Our Ref: AB/135/18/HH
Your Ref:

Town & Country Planning Act 1990 (as amended)
Town & country Planning (Development Management Procedure) (England) Order 2015
Application for Planning Permission for Works or Extension to a Dwelling

Development Replacement timber and glass conservatory structure within outbuildings in yard / garden.
Location 2 Kings Arms Hill Arundel

EXISTING PLAN & ELEVATIONS
OF CONSERVATORY &
OUTBUILDINGS
MARY BAYFORD
2 KING'S ARMS HILL
ARONDEL
WEST SUSSEX
BN18 9ET
BRG NO MB/1118/PA/LEC/03
NOVEMBER 2018 JR.

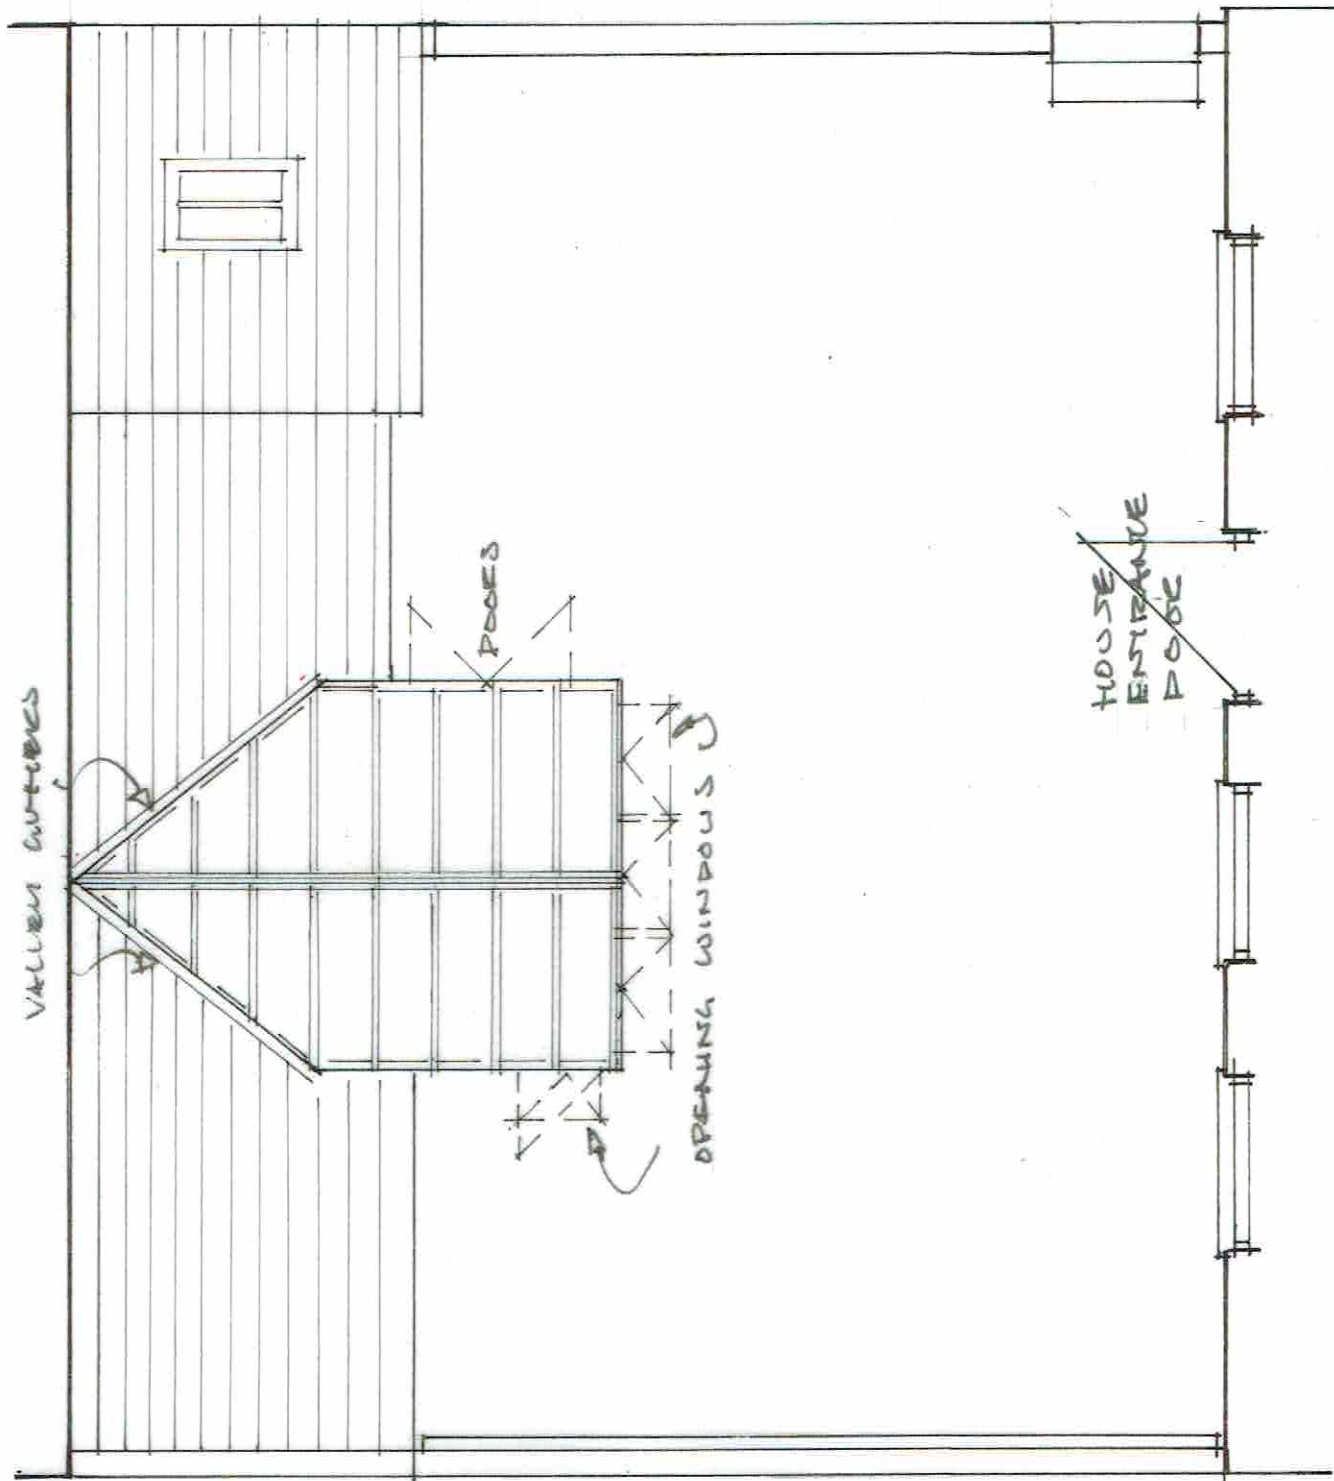
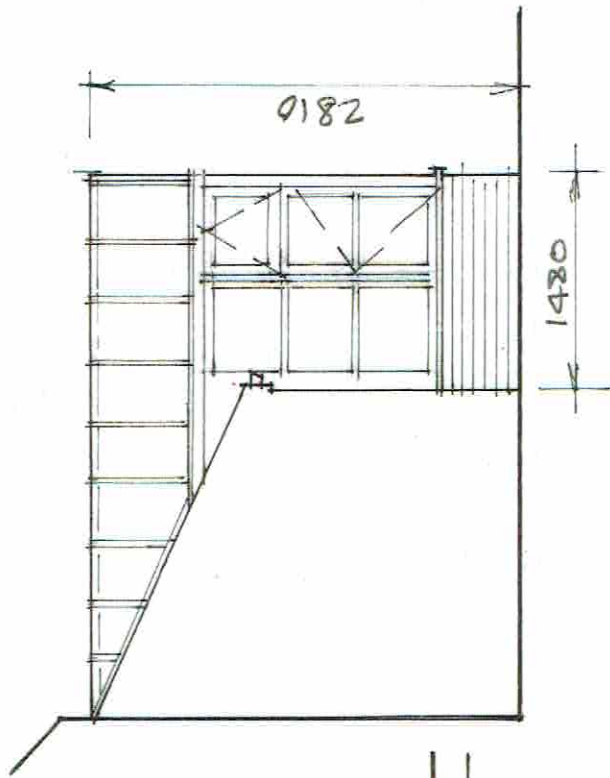
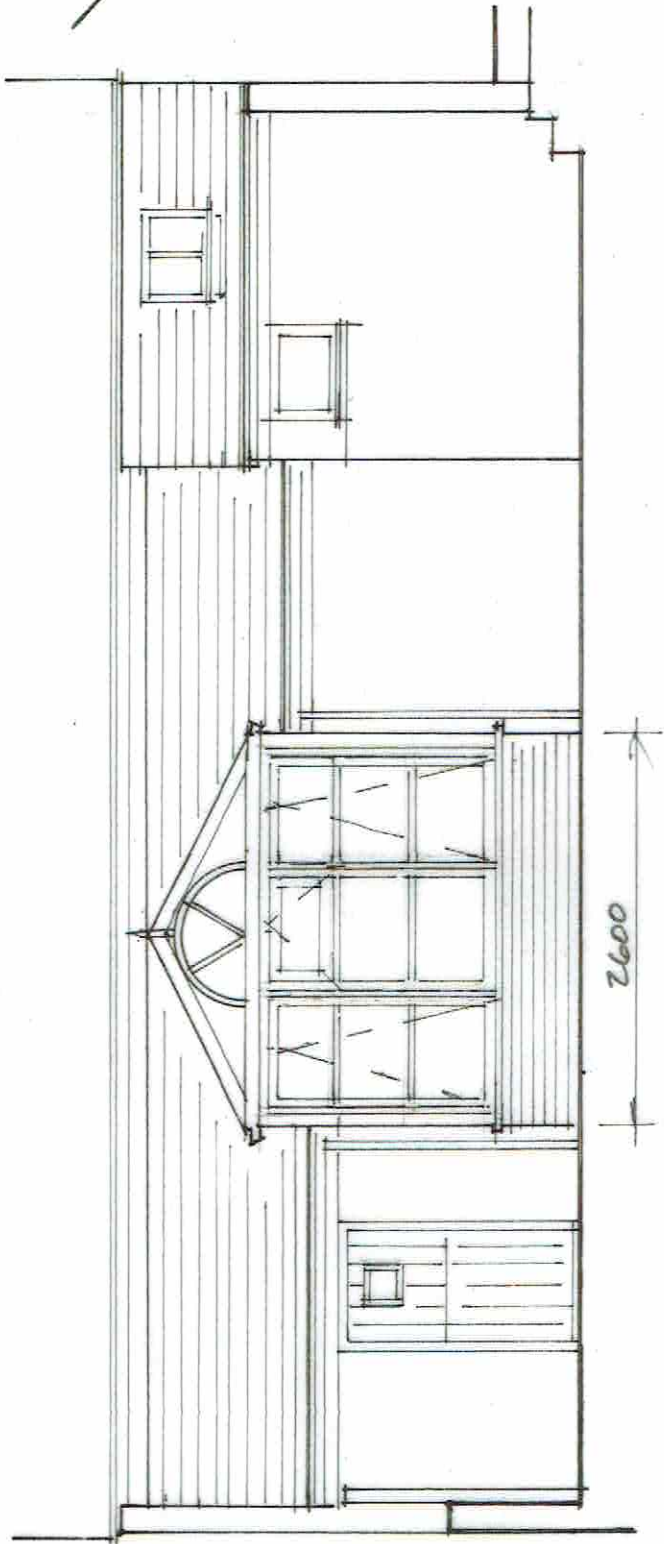
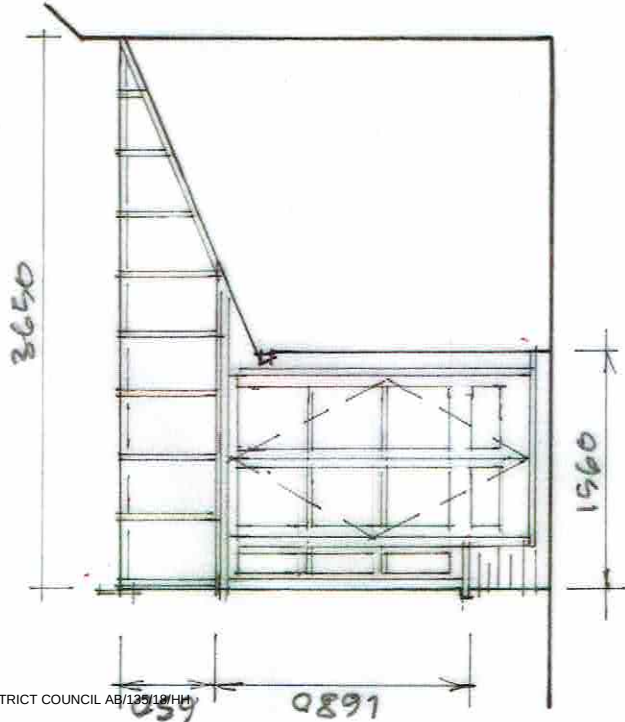
Inconsistent: The existing block plan is inconsistent with the design & access statement as it claims that the existing conservatory has a 5 pane glass roof but the block plan is showing 7. Please confirm which is correct and amend as necessary.
